FAO: Planning Department,  
Welwyn Hatfield Borough Council

Ref: 6/2018/0136/LB  
Date: 22/10/2019

## HISTORIC BUILDINGS AND CONSERVATION ADVICE

**RE: *Oshwal Centre, Coopers Lane, Northaw, Potters Bar, EN6 4DG***

DRAWING TITLE
 WINDOWS 18-19-20

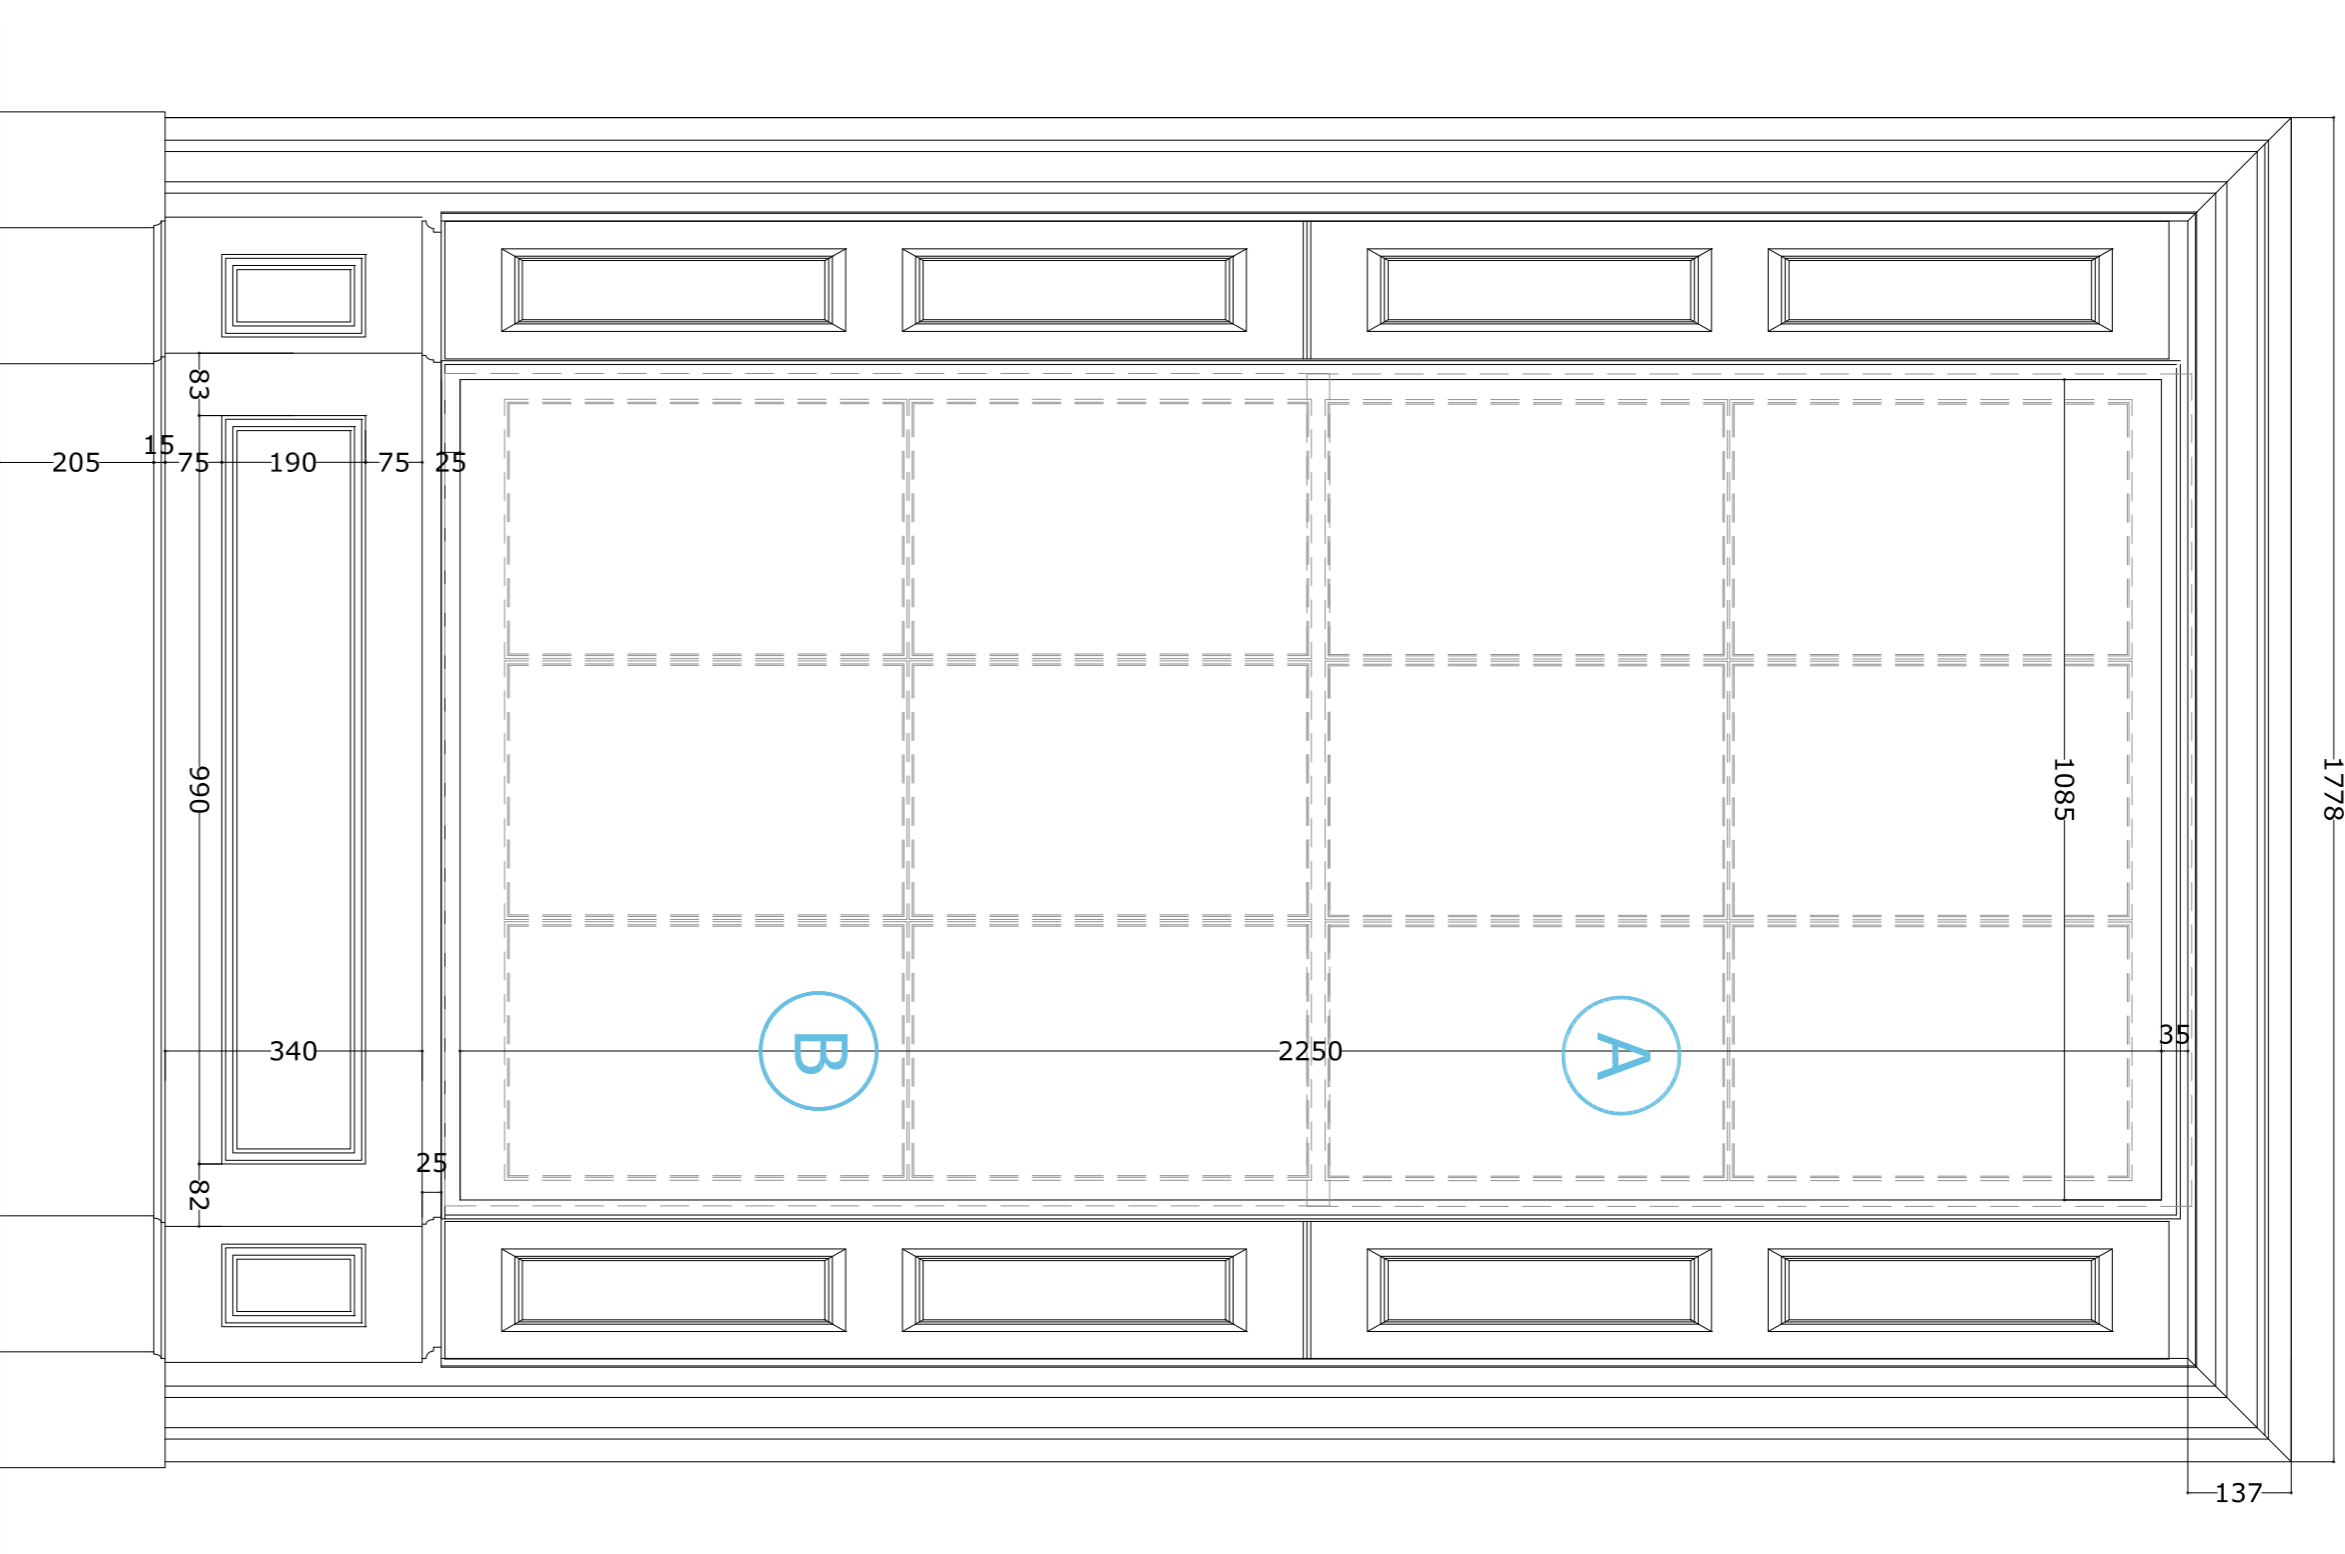
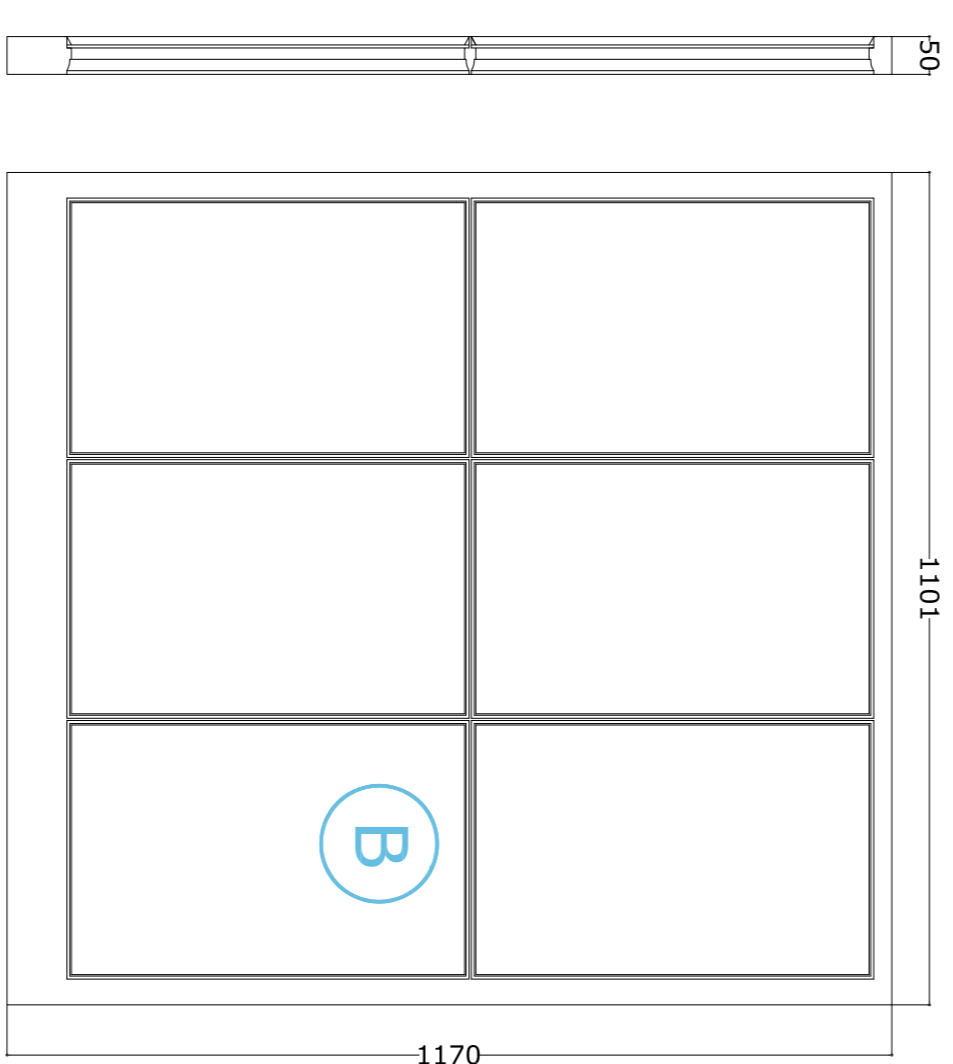
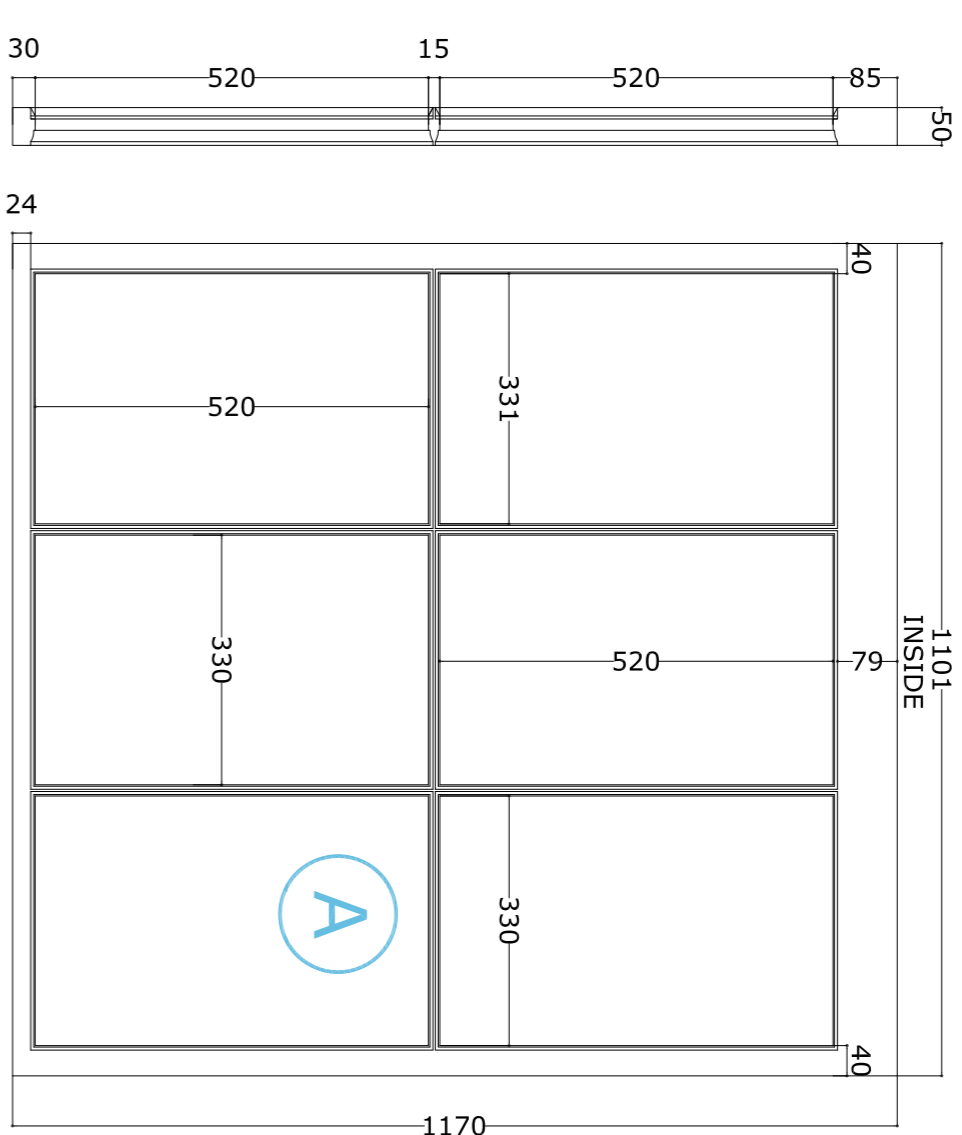
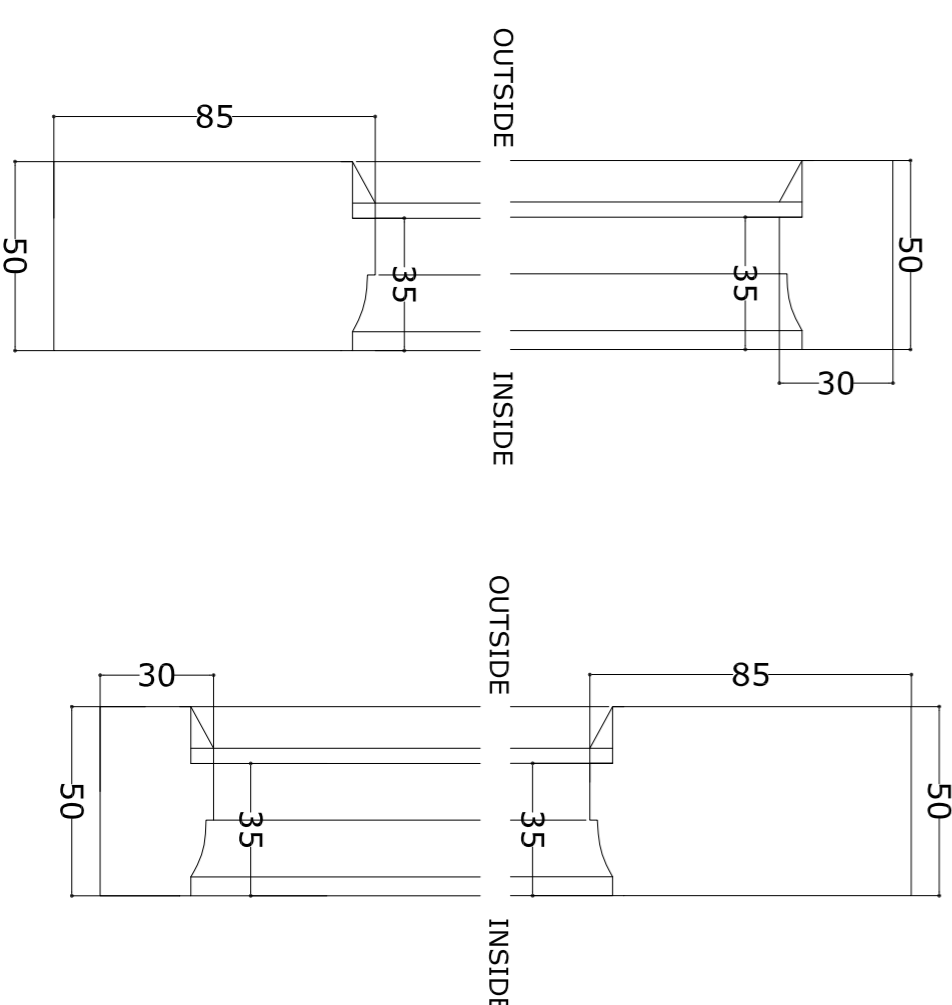
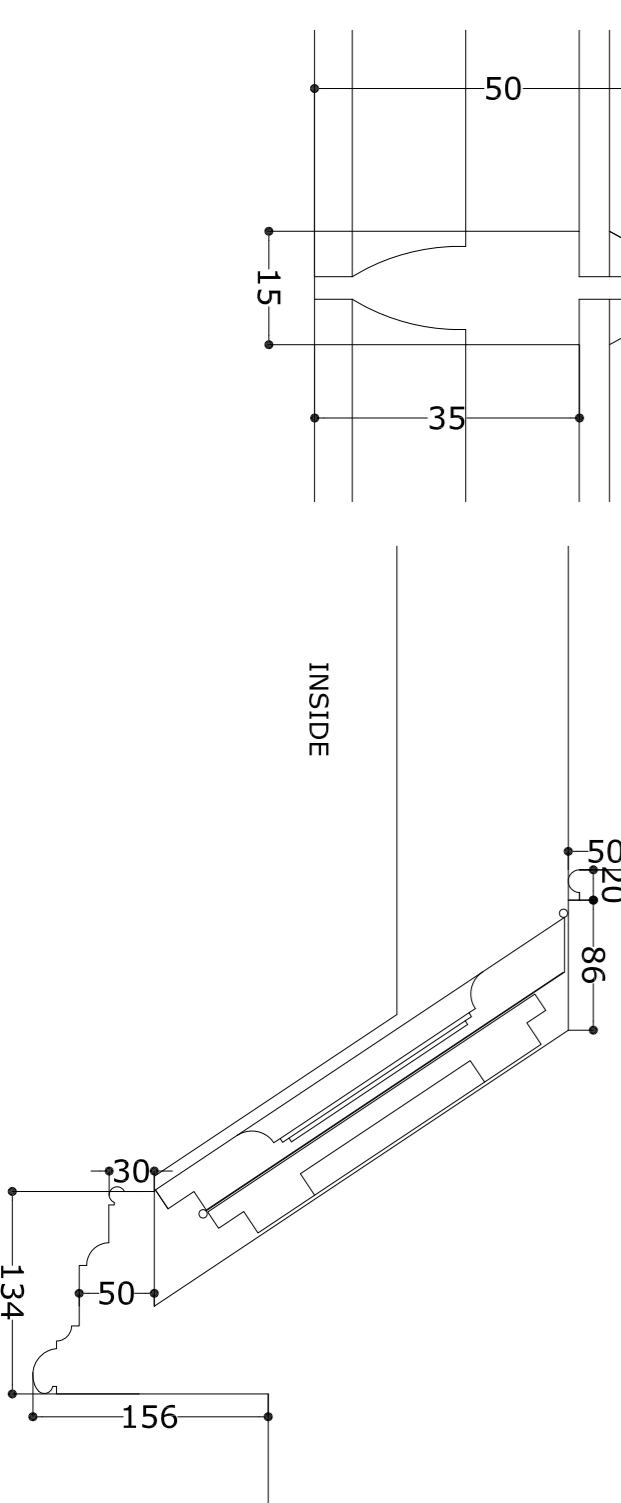
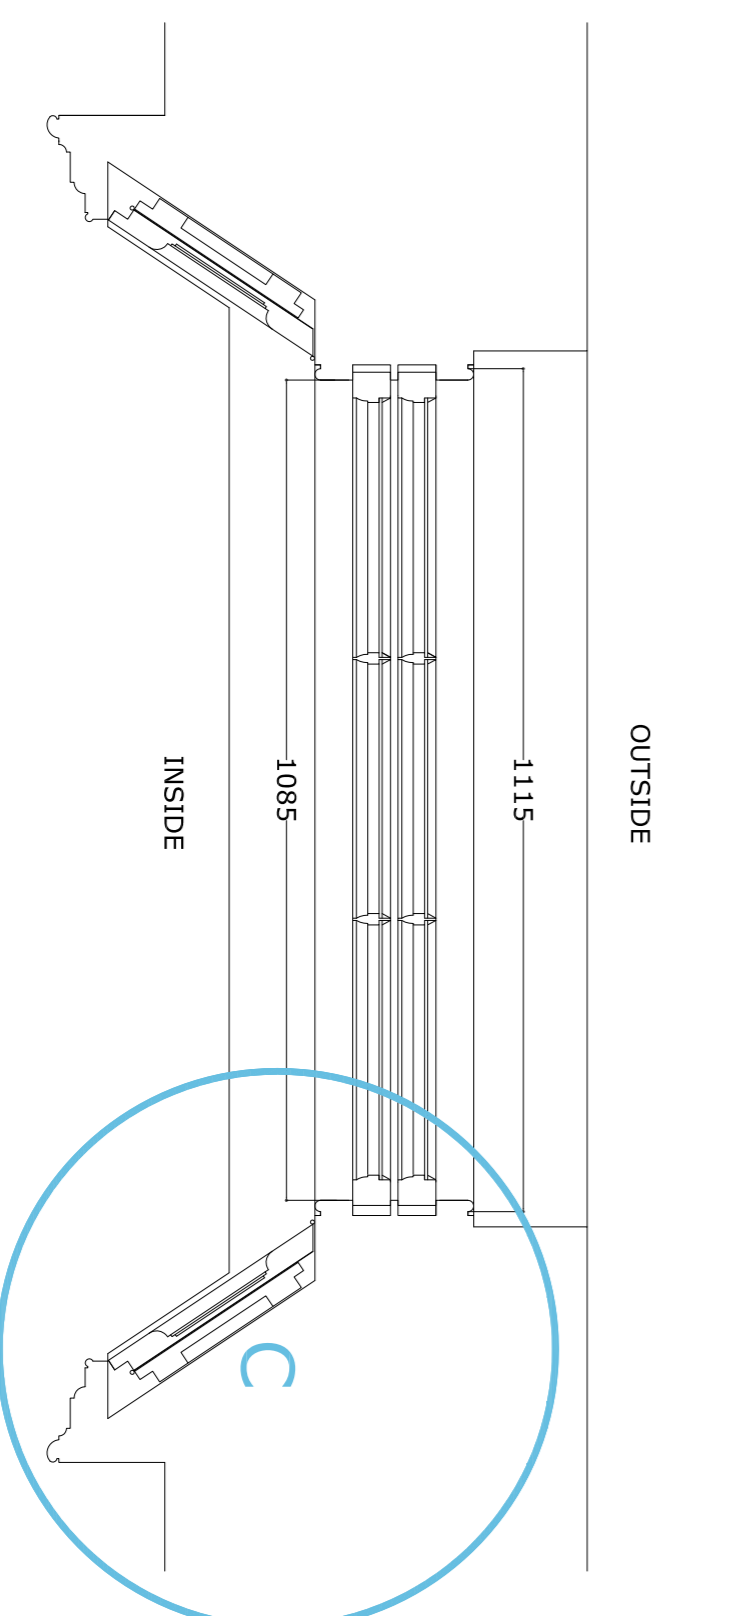
The repair of window nos. 1, 2, 3, 12, 13, 14, 15, 16, 17, 18, 20, 21, 22, 23, 24, 25, 26, 38, 39, 40, 41, 42, 43, 44, 45, 46, 47, 48 (refer to paragraph no. 2.11 of the *Heritage Statement Annex 1* and drawing no. 6842-78-P0) is supported. These windows appear to be original to the 1839 section of the house and therefore relate to the primary phase of the building. However, further detail is required on the repair needed to these windows as the *Heritage Statement* is quite general. Detail is required as to the extent of the repair work, the technique/methodology materials to be used. The proposed replacement of the single glazing with slim double glazing is not acceptable because of the potential loss of historic glass and the untraditional modern appearance of double glazing.
